Response to Section 51 advice for Thanet Extension

Thanet Extension Offshore Wind Farm

Appendix 1 to Response to Section 51 Advice:
Section 44 consultees

### Land Plan (Onshore) - Sheet 0

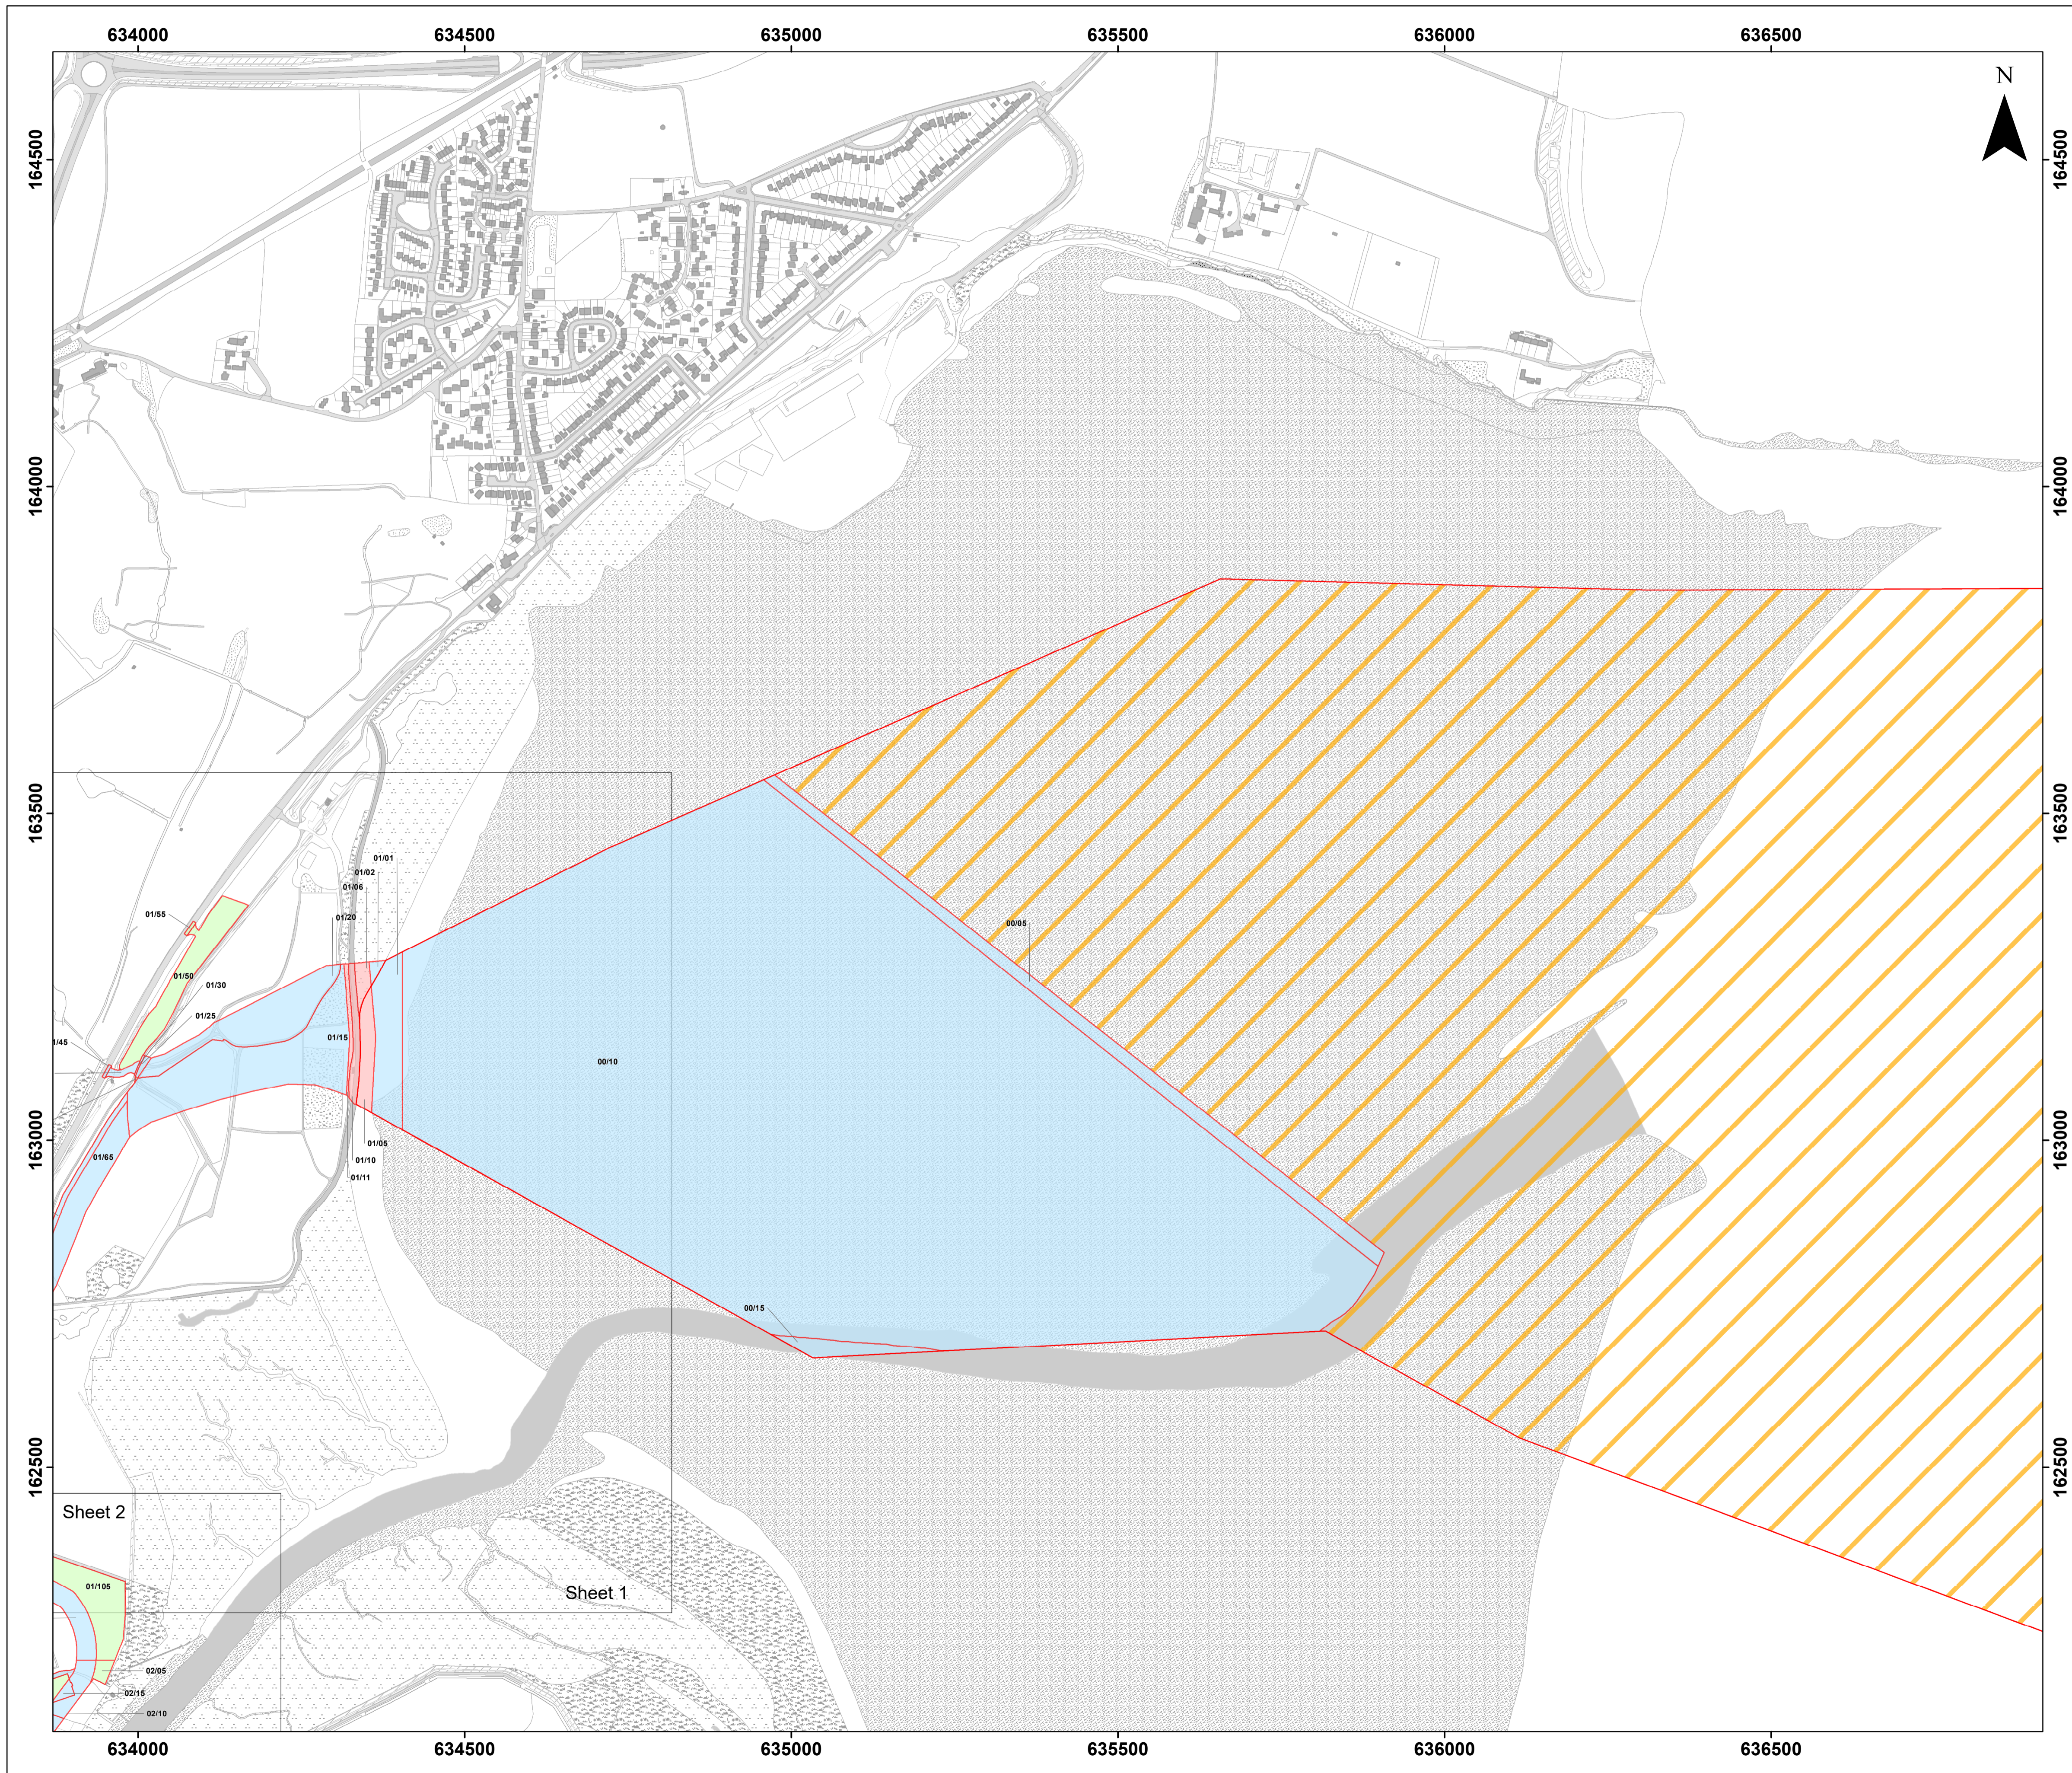
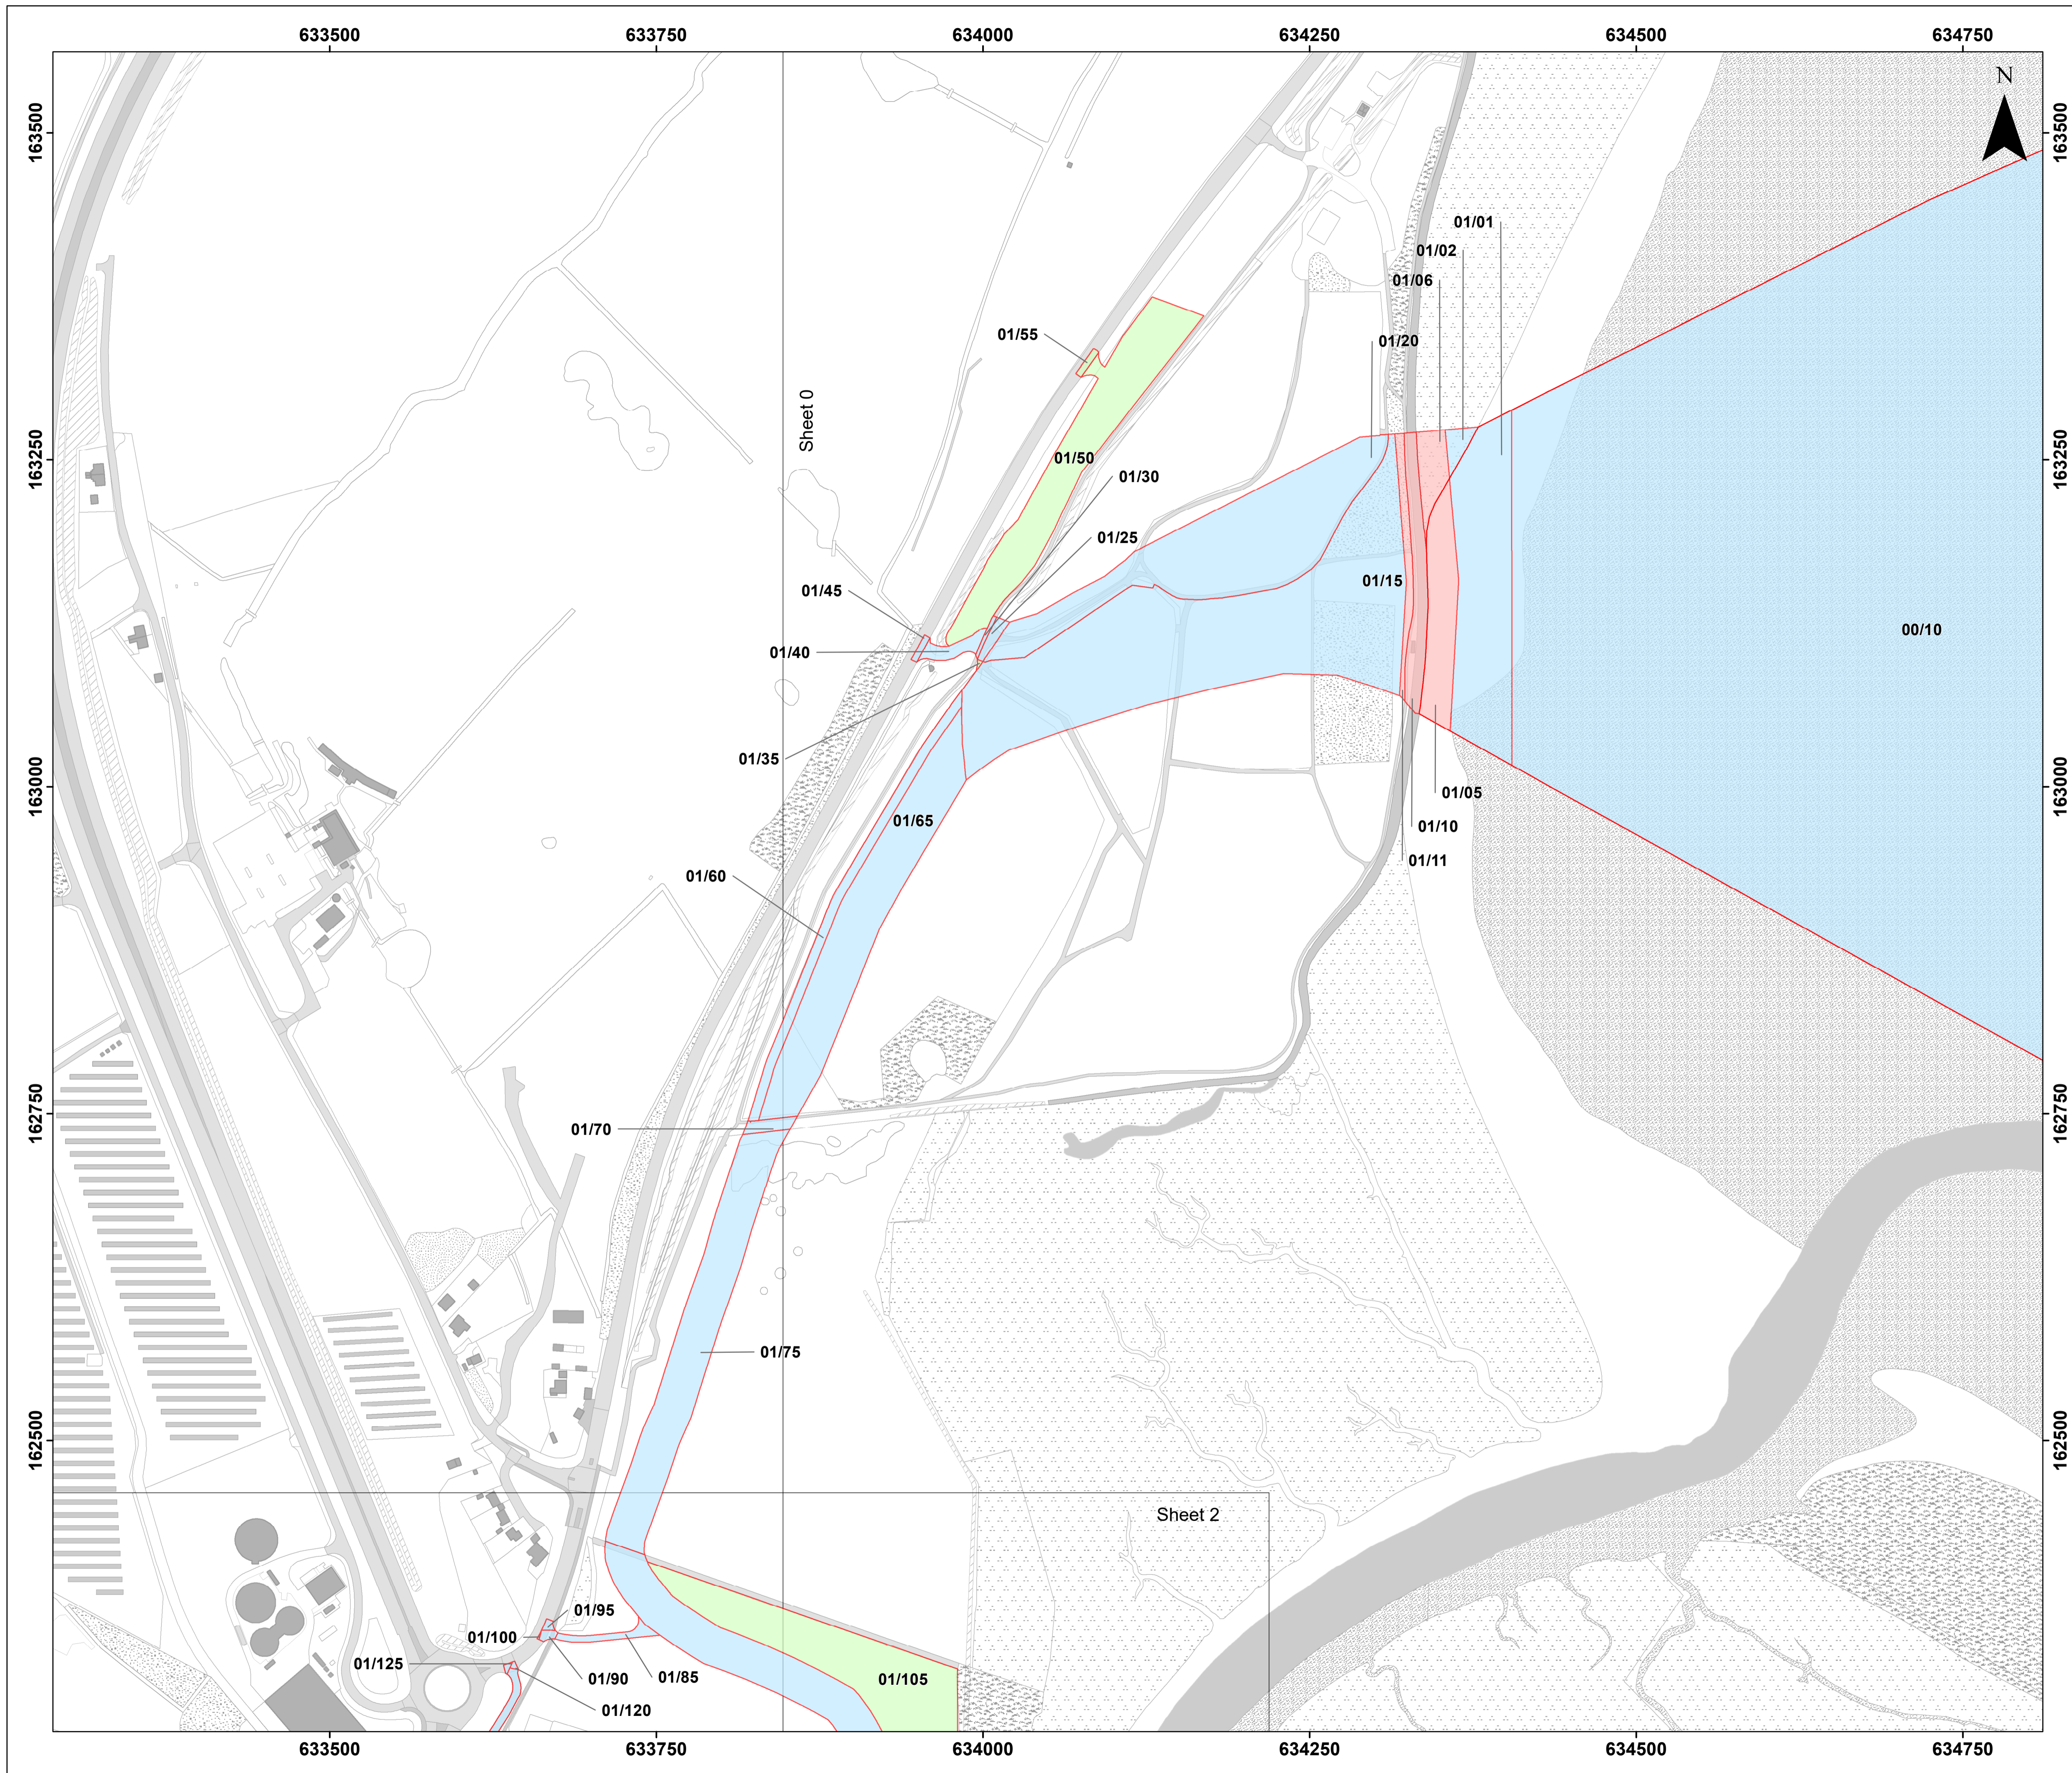
PINS comment in Section 51 letter	Applicant's response
<p>Please provide updated Land Plans that can be read which include:</p> <p>All relevant landmarks as described in Column 2 ('Description of Land') of the BoR e.g. Pegwell Bay Country Park, Sandwich Road, Ebbsfleet Roundabout and the A256 to be reflected on the relevant Sheets associated to the Land Plans.</p> <p>Insets to assist the reader.</p> <p>All plots on the individual sheets to be provided with the correct plot reference and colour code which is consistent with the other application documents.</p>	<p>This will provided at least 10 days prior to the Preliminary Meeting</p> <p>Landmark descriptions have been added to the OS mapping for clarity.</p> <p>Insets where requested have been added.</p> <p>This has been updated as per PINS' specific comments below.</p>
PINS comment in Section 55 checklist	Applicant's response
<p>The legend on the plans identifies blue coloured plots as 'Permanent acquisition of new rights'. Should this be 'Creation of new rights' or 'Extinguishment of rights'?</p> <p>Plot 01/35 could benefit from an inset as it is unclear whether this plot is coloured green or blue. The Book of Reference refers to temporary rights and the plot is included in Schedule 7 of the DCO (Land of which Temporary Possession may be taken). However the plot is also included in Schedule 5 (Land in which only New Rights etc., may be acquired).</p>	<p>The Applicant has reviewed this wording and the description used in other applications and is content that this accurately describes the approach taken.</p> <p>An inset has been added for Plot 01/35.</p> <p>Plot 01/35 is correctly scheduled for both temporary possession and the acquisition of permanent new rights, in keeping with the Applicant's strategy for the majority of the plots within the Order Limits.</p> <p>The Book of Reference has been updated to reference both rights of temporary possession and new rights; a revised Book of Reference will be submitted at Deadline 1.</p>

Plot 01/50 is coloured green on the land plan, showing it is temporary possession and is included in Schedule 7 of the DCO (Land of which Temporary Possession may be taken) and not in Schedule 5 (Land in which only New Rights etc., may be acquired). However the Book of Reference refers to new rights.	The Book of Reference has been updated to reference both rights of temporary possession and new rights; a revised Book of Reference will be submitted at Deadline 1.
Plot 01/55 is coloured green on the land plan, showing it is temporary possession and is included in Schedule 7 of the DCO (Land of which Temporary Possession may be taken) and not in Schedule 5 (Land in which only New Rights etc., may be acquired). However the Book of Reference refers to new rights.	The Book of Reference has been updated to reference both rights of temporary possession and new rights; a revised Book of Reference will be submitted at Deadline 1.

Plot 01/105 is coloured green on the land plan, showing it is temporary possession and is included in Schedule 7 of the DCO (Land of which Temporary Possession may be taken) and not in Schedule 5 (Land in which only New Rights etc., may be acquired). However the Book of Reference refers to new rights.	The Book of Reference has been updated to reference both rights of temporary possession and new rights; a revised Book of Reference will be submitted at Deadline 1.
The area containing plot 01/100 on sheet 1 of the Land Plan Onshore could benefit from an inset.	An inset has been added for Plot 01/100.
Plots 01/80 and 01/115 are not identified on sheet 1 of the Land Plan Onshore.	This issue has been addressed by amending the cut lines to ensure these plots are properly identified.
Plot 01/110 is only identified on sheet 2 of the Land Plan Onshore. Should this plot be assigned an 02 reference?	This issue has been addressed by amending the cut lines to ensure these plots are properly identified.

Plot 02/05 is coloured green on the land plan, showing it is temporary possession and is included in Schedule 7 of the DCO (Land of which Temporary Possession may be taken) and not in Schedule 5 (Land in which only New Rights etc., may be acquired). However the Book of Reference refers to new rights.	The Book of Reference has been updated to reference both rights of temporary possession and new rights; a revised Book of Reference will be submitted at Deadline 1.
Plot 02/85 is identified on the land plan as permanent acquisition but in the Book of Reference as new rights. This plot is not identified in the schedule 5 of the DCO (Land in which only New Rights etc., may be acquired).	This Plot is correctly shaded pink for freehold acquisition on the Land Plans, and accordingly is correctly omitted from schedules 5 and 7 of the DCO. The Book of Reference has been updated to reflect the DCO and will be submitted for Deadline 1.

In the legend 'Cable route options' does not describe what rights are being sought.	The legend has been amended to read 'Cable route options – Permanent acquisition of new rights'.
No landmarks or road names are identified on the land plans	This has been updated on Land Plans and specific land mark names, where needed, have been added to the OS mapping.
The scale is not in compliance with Regulation 5(4A) of the APFP Regulations, for the onshore plan sheet 0.	This sheet has been changed to 1:2,500.
